Development Facilitation Team (DFT) – Review Comments

Project No: PR-2023-009209 Date: 02/14/2024 Agenda Item: #3 Zone Atlas Page: NR-BP

Request: Proposing A 93K GSF Expansion of an existing 90K GSF Manufacturing Warehouse at 6625 Bluewater Road NW. This will include improvements for additional Onsite Parking, Onsite Drainage Features, Landscape, Lighting, and Wet Utilities.

Application For: SI-2024-00158 – SITE PLAT DFT

PROJECT NO.  
096523009  
 SHEET  
 C1.0

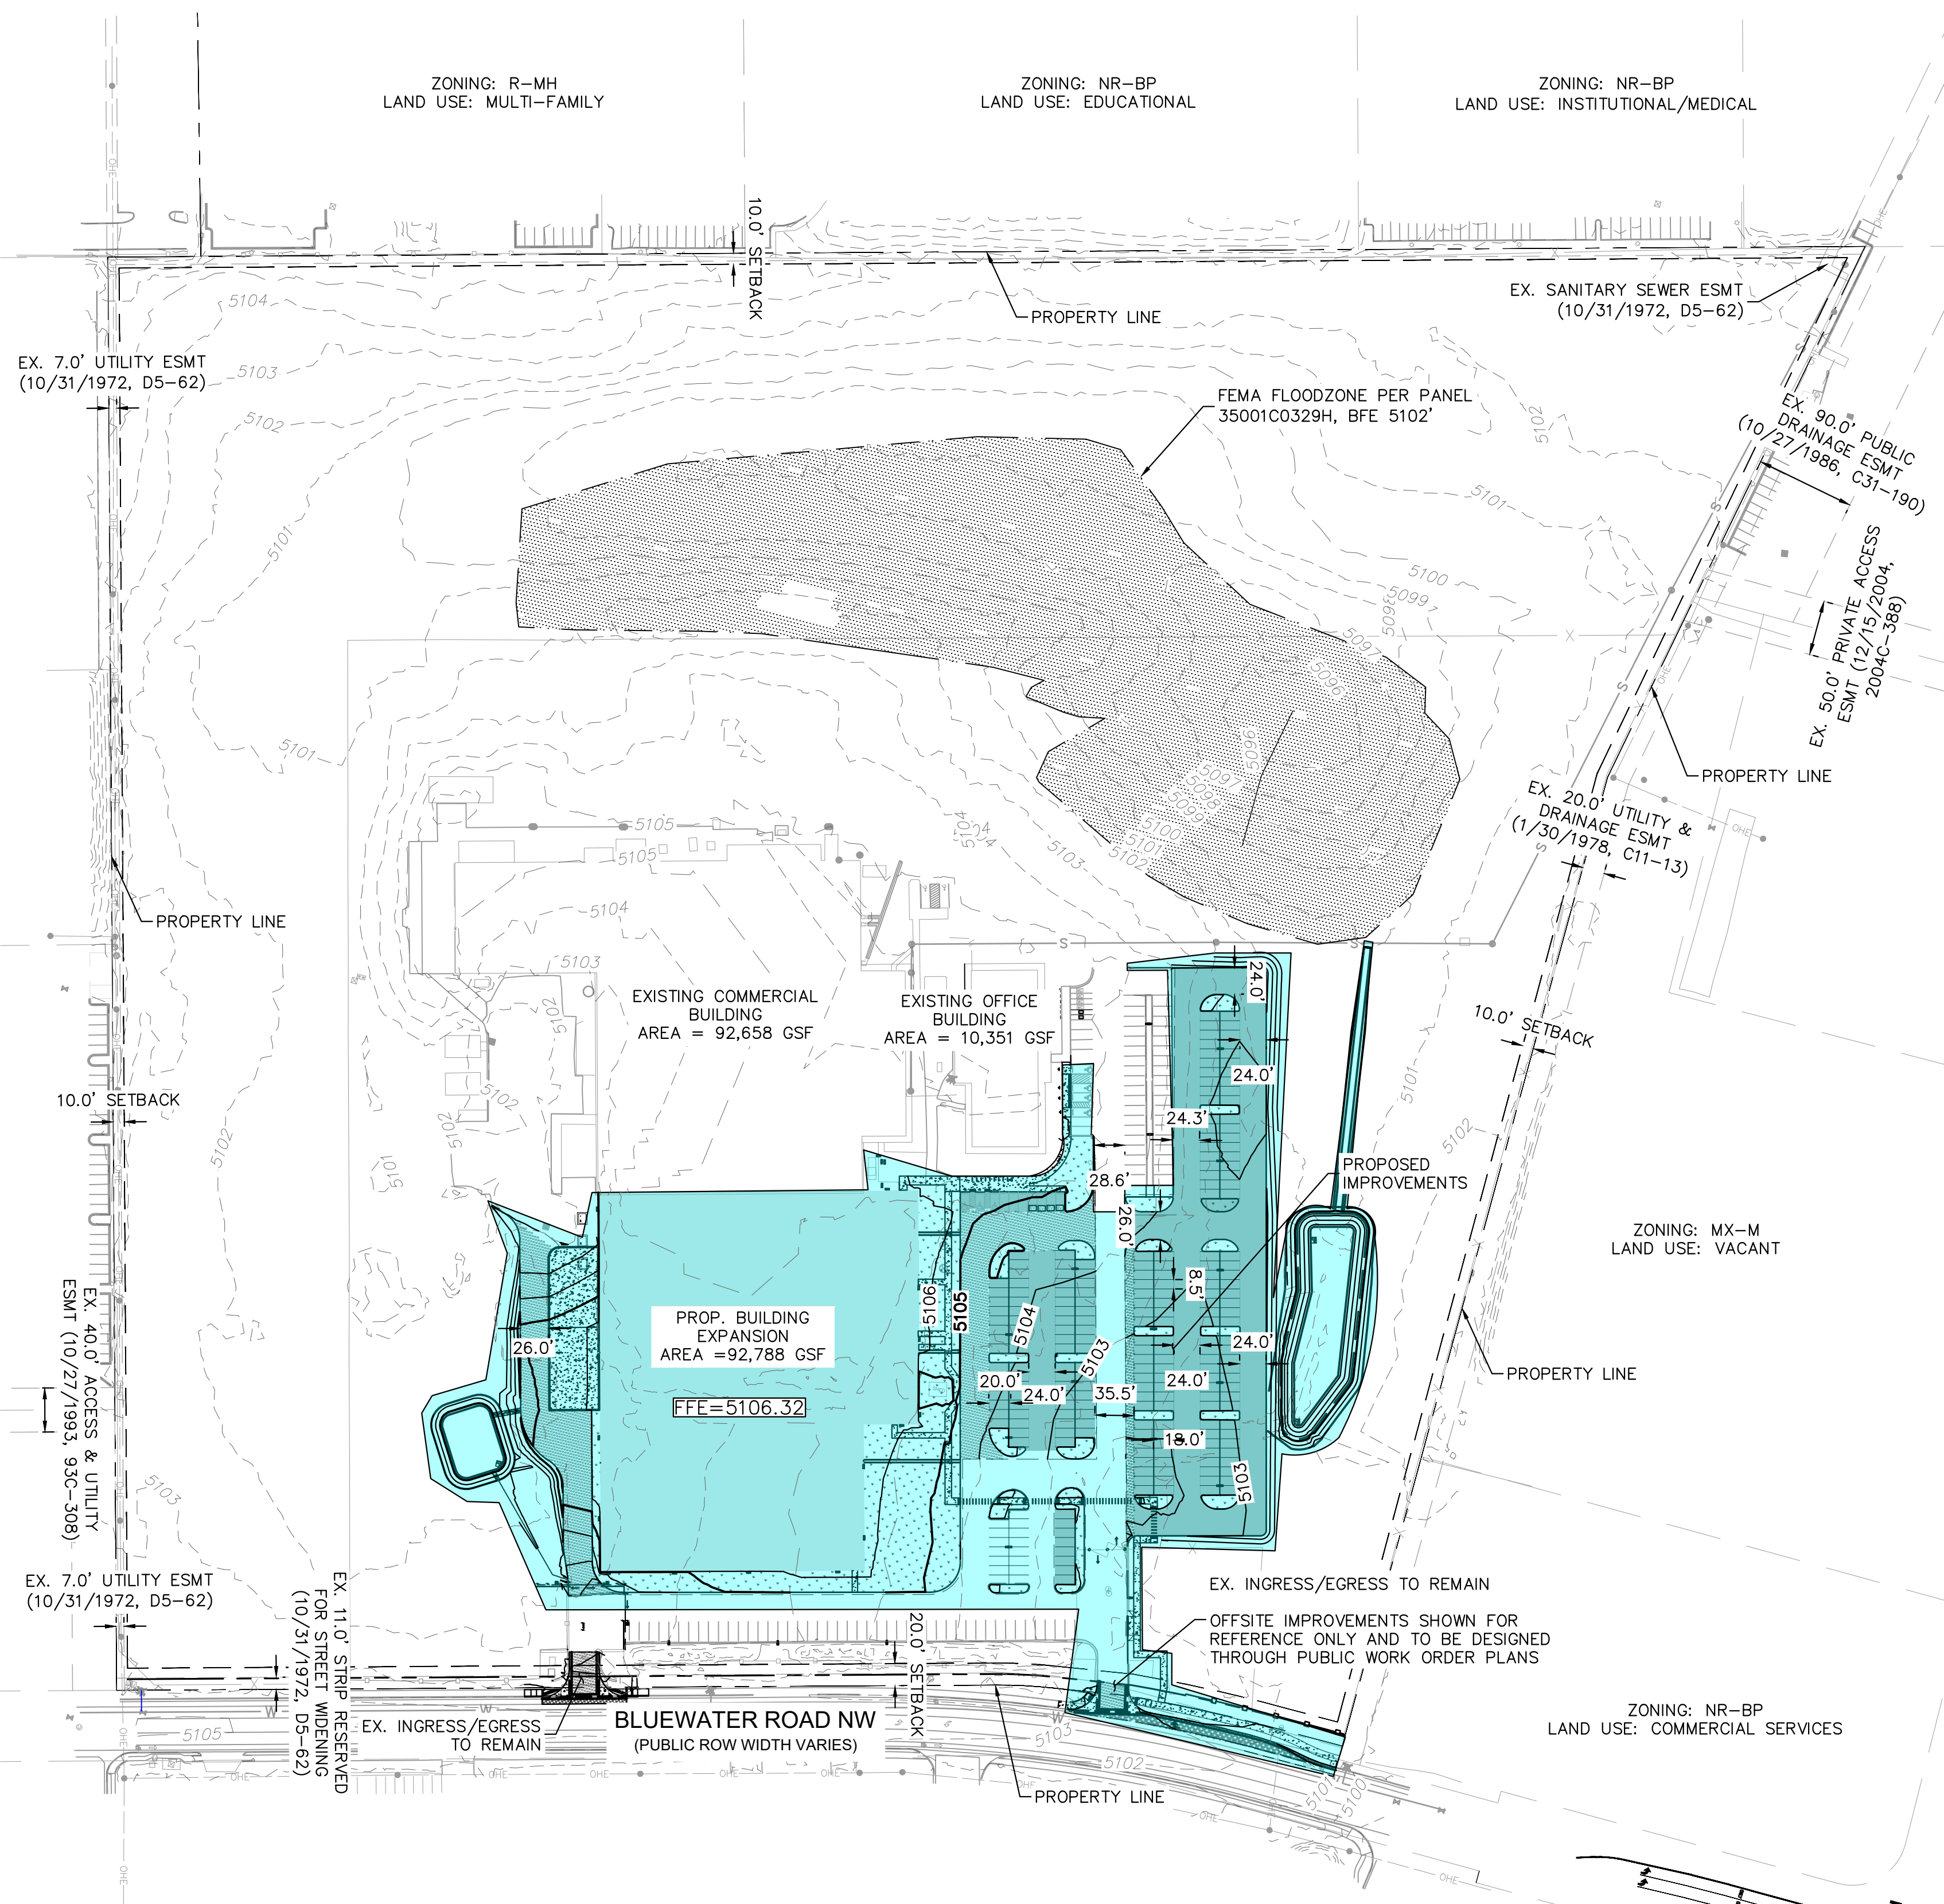
2. Please clarify all specific uses for parking calculations, such as areas to be used for Office, Light Manufacturing, Warehouse or Storage, etc.
3. Show how you are meeting the requirements for the required Outdoor Seating and Gathering area, as per 5-11(E)(3) – provide calculations. Requires one outdoor seating area of at least 400 sq ft for every 30,000 gsf.

2. Added note on sheet C1.0 stating the specific uses of the parking. The parking provided is for Light manufacturing (F-1) and Office (B).

3. Outdoor seating and gathering area is already existing. Refer to sheet C1.1 for the callout (between existing office & existing manufacturing warehouse) and refer to sheet C1.0 for the calculations table. Survey did not provide seating within the survey.

SHEET  
**C5.5**

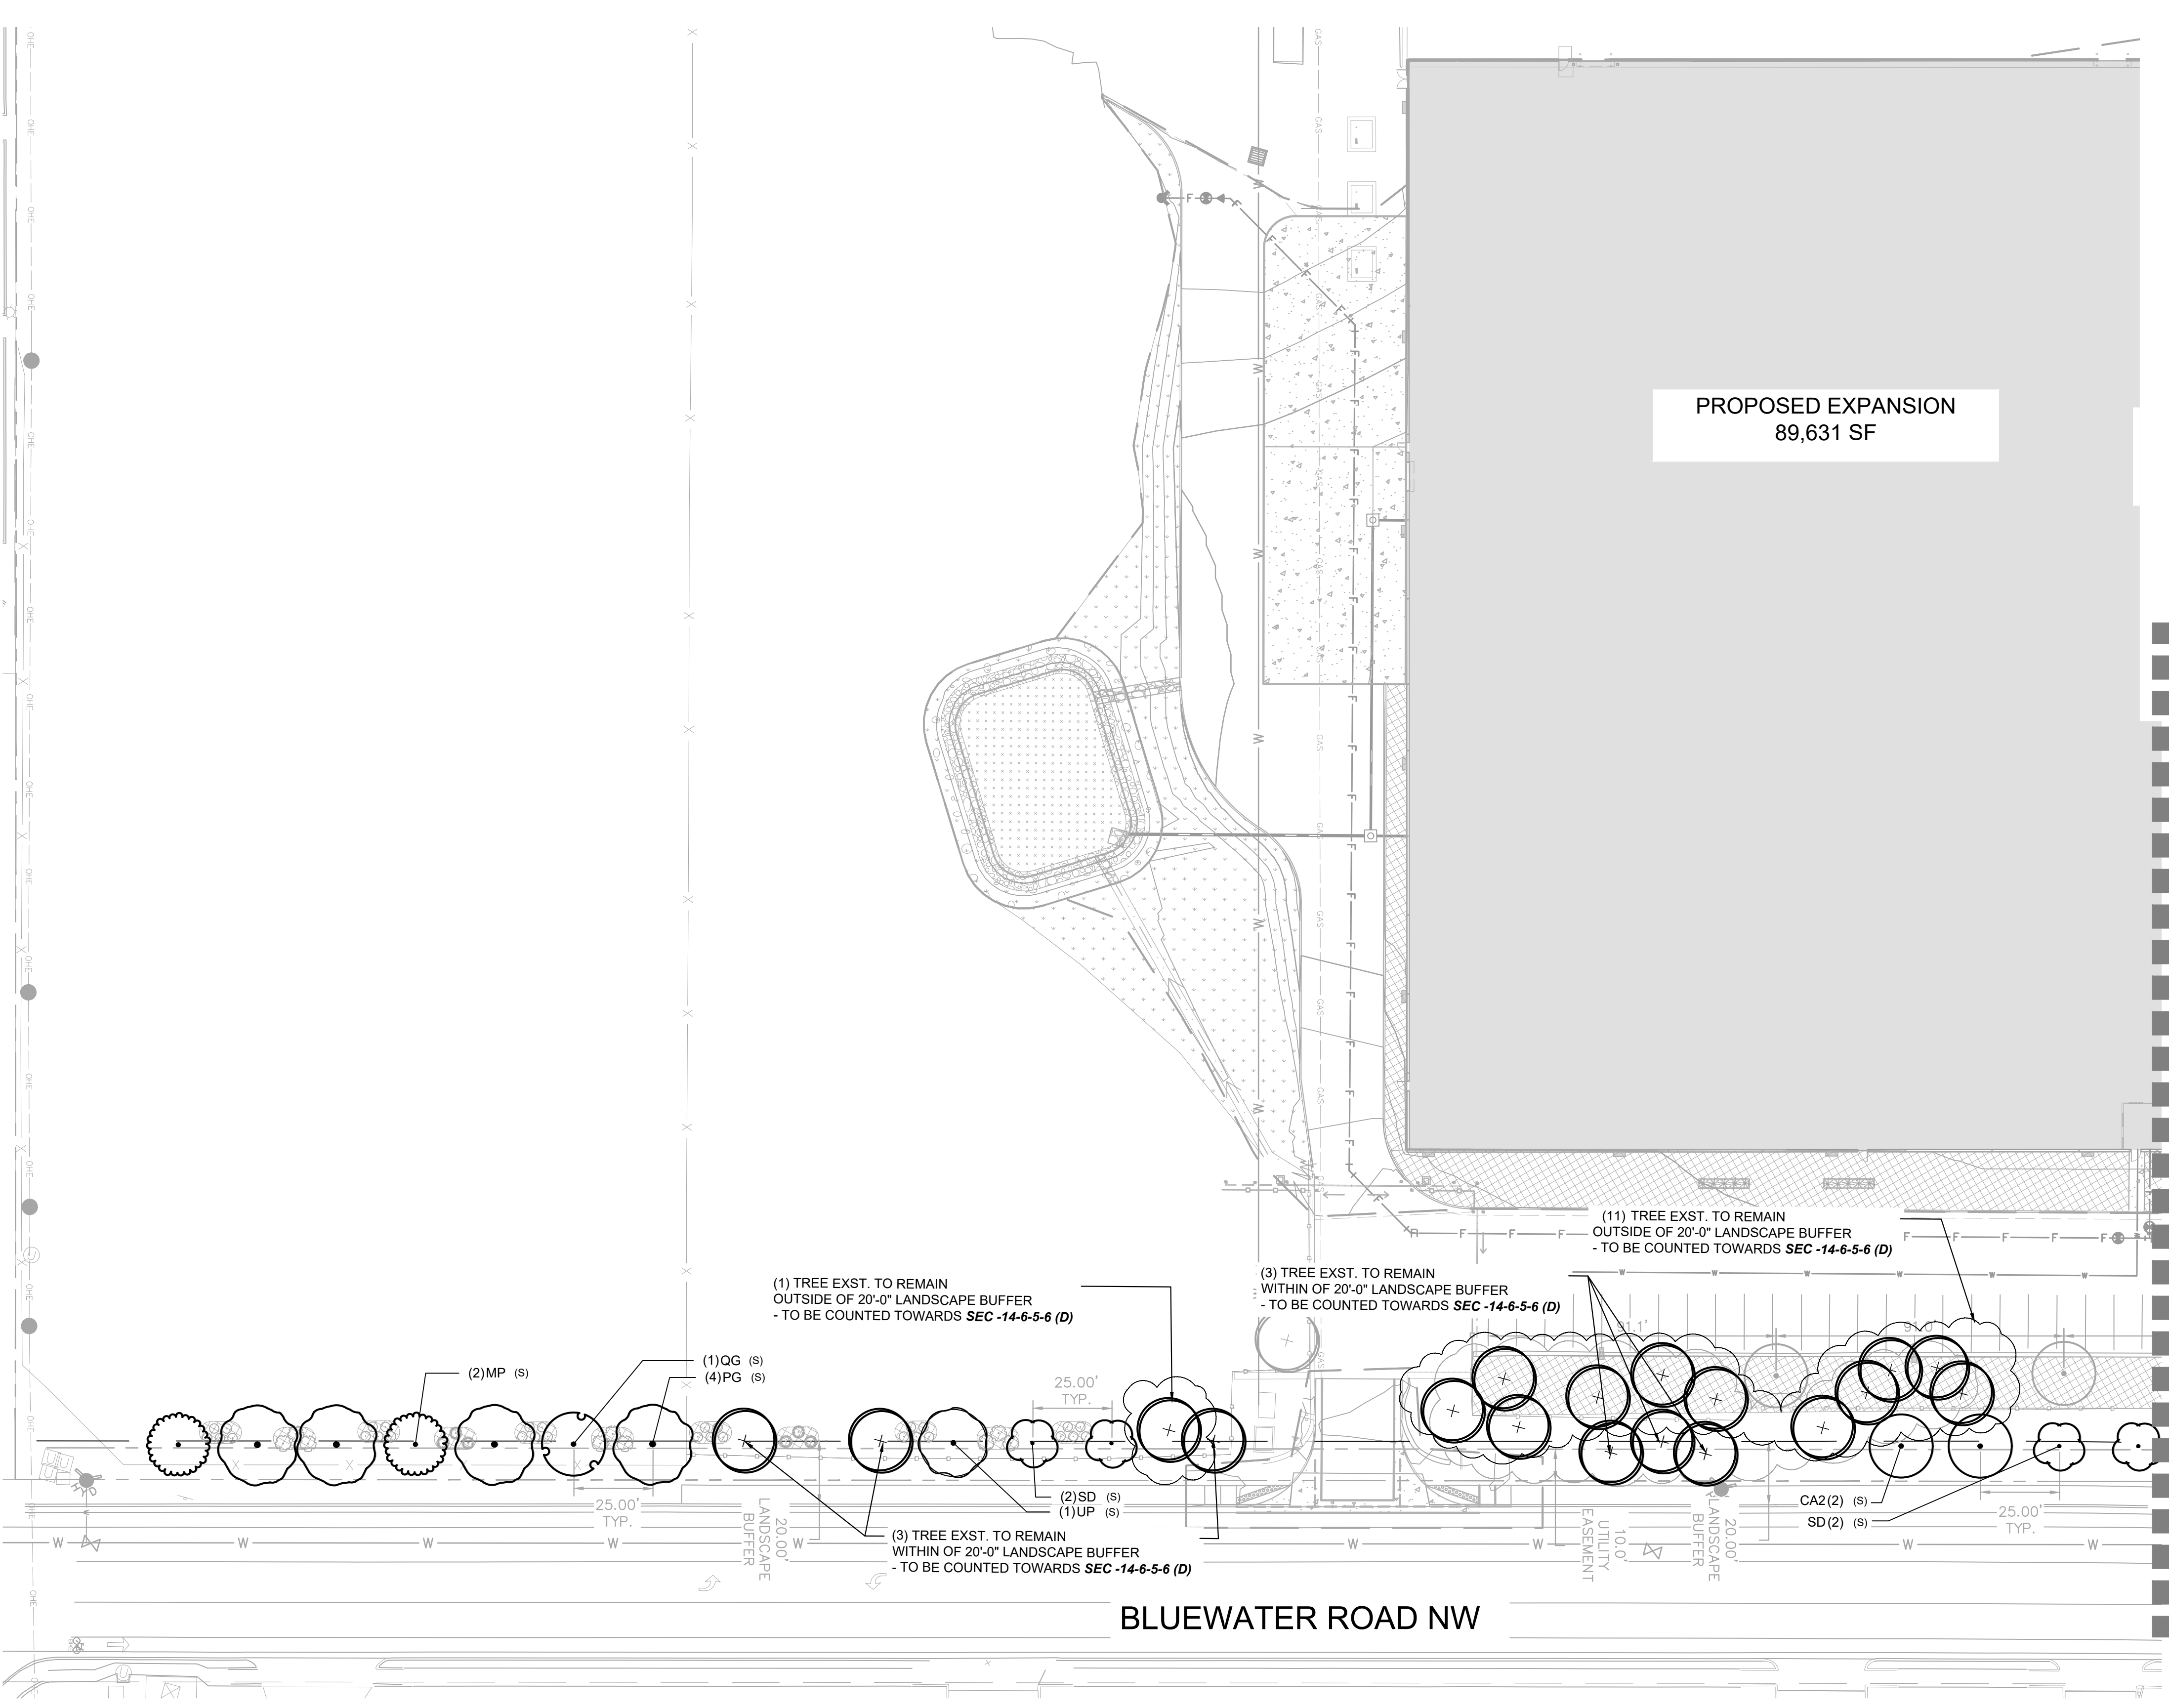
Please detail on the landscaping plan how the new street frontage trees are meeting the requirements in IDO 14-16-5-6(D)(1)(a), specifically the distance between species and the distance from the back of the curb on Bluewater.

1. Plans have added dimensions to show code compliance. Trees have been adjusted to fit within the 20'-0" landscape buffer and newly proposed 10'-0" UT easement. Proposing to meet code req. using existing trees on site that are outside of 20'-0" buffer. See alternate"

**OVERALL ELEVATION - NORTH - SDP**

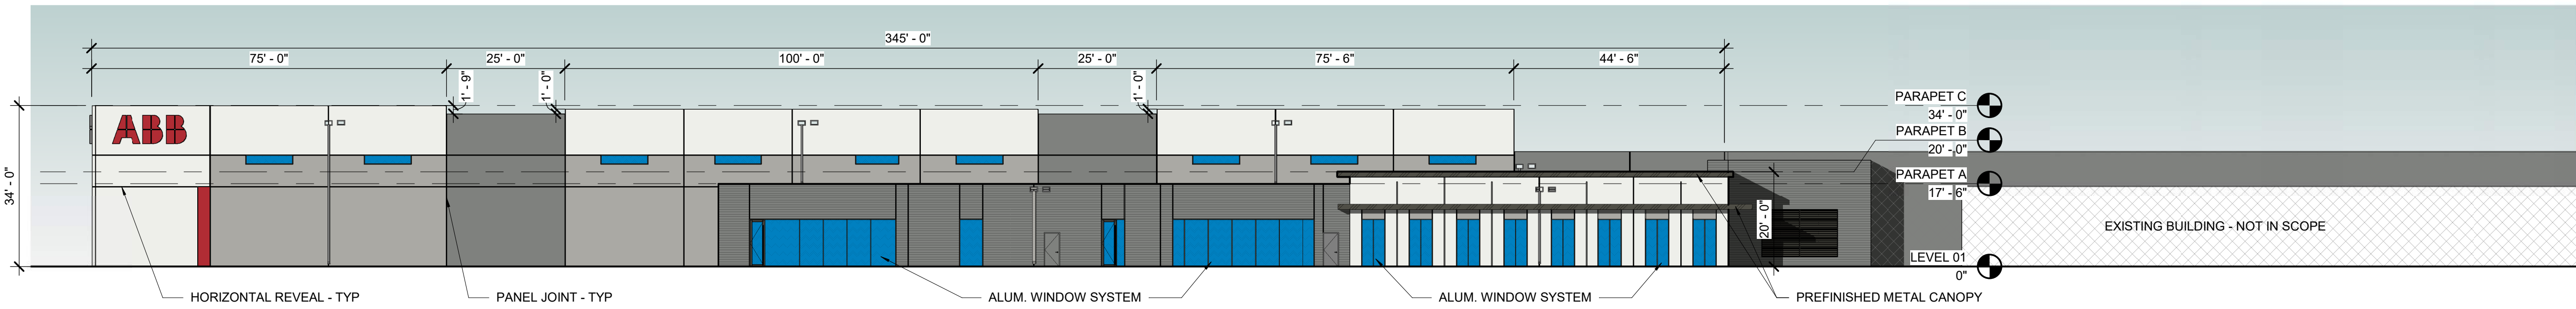
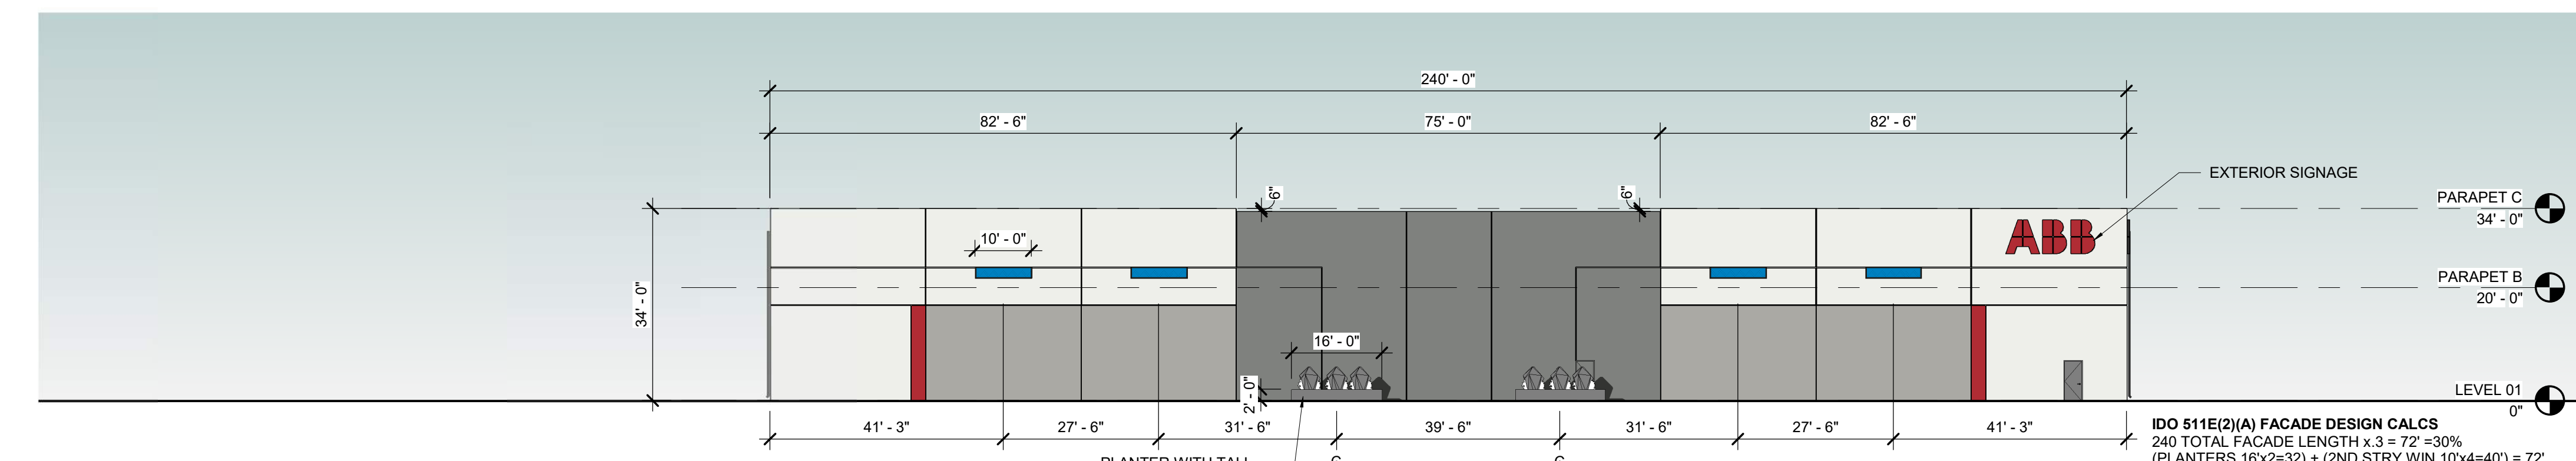
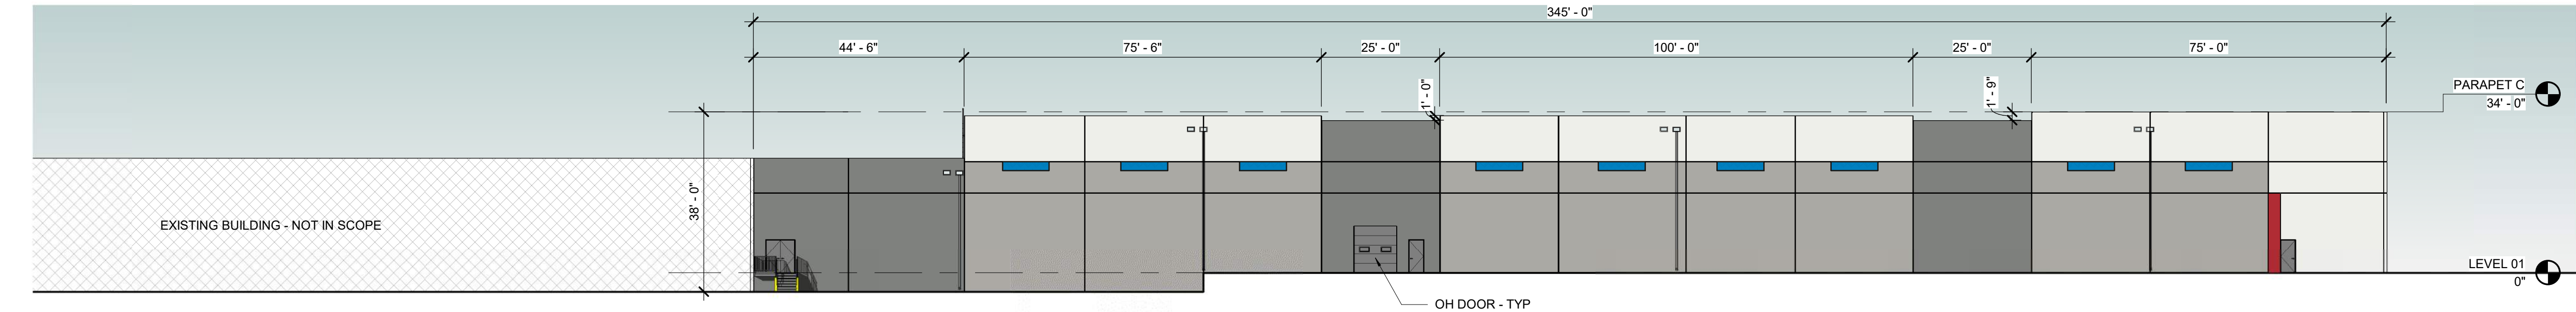
▪ Elevation pages were included in the submittal. *Please explain how the façades are meeting the requirements of CPO-2 and 5-11.*

1. The use of colors that contrast with the predominant color of the building is limited to 10 percent of each façade.
2. Parapet walls shall be treated as an integral part of the building design. Such walls shall not appear as unrelated visual elements.

1. The ABB factory addition has been designed with equally annunciated facades on all sides. Building panel heights are varied throughout and paired with color banding to create a diversity of structural forms. The buildings entry is part of smaller annex which provides a sense of scale for the glazing and moment for elevated materials. Texture wall materials are used to soften the scale and add a quality to the entry experience.
